APPLICATION NO: 24/00103/FUL/ADDINF
DESCRIPTION: Proposed single story rear extension.
LOCATION: 3 Atrebatti Road Sandhurst Berkshire

EXISTING FLOOR PLAN

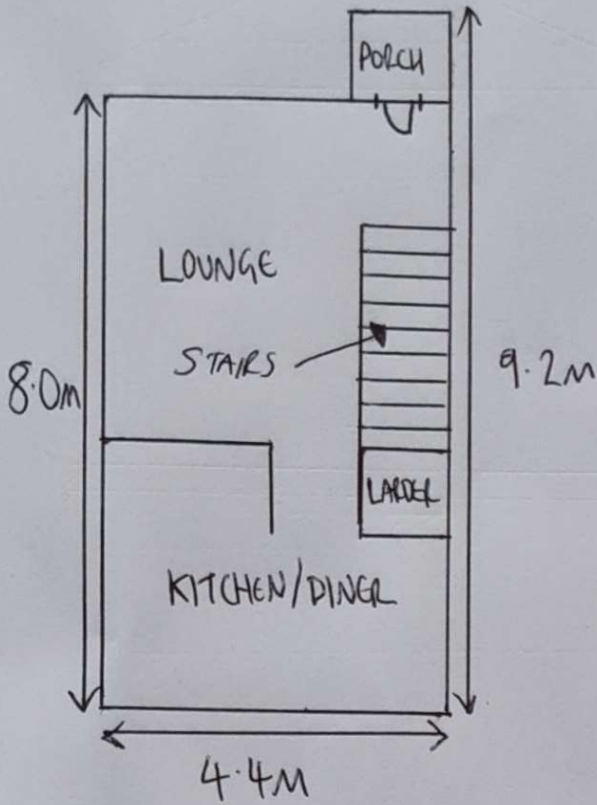
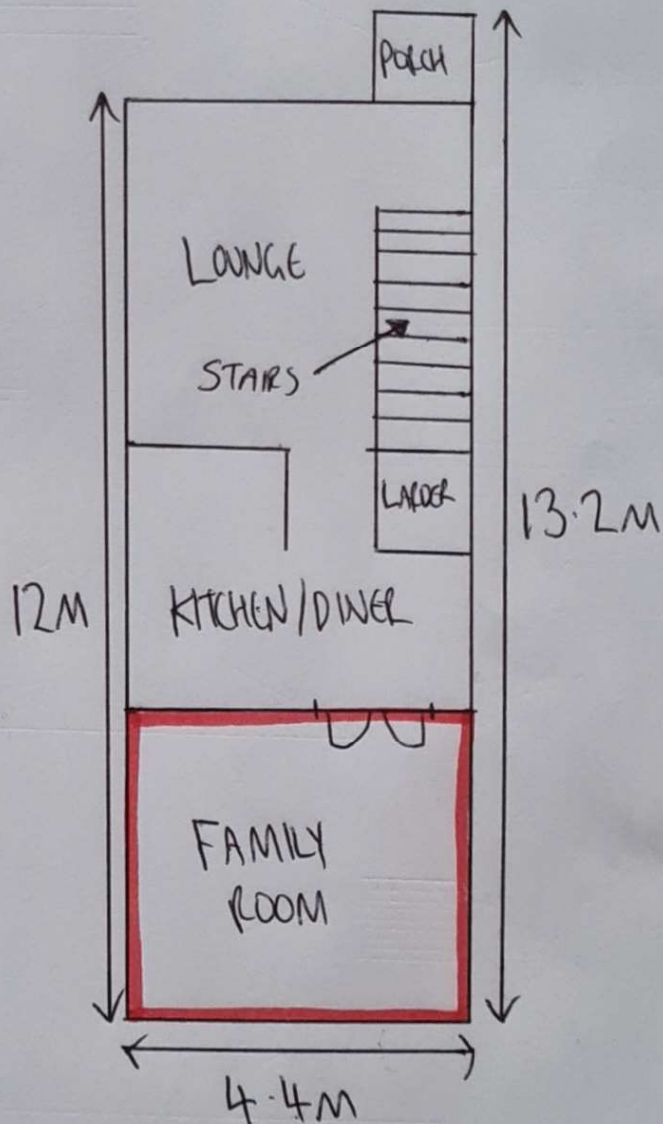
- 1 Please show all external doors and windows on the existing and proposed floor plans.
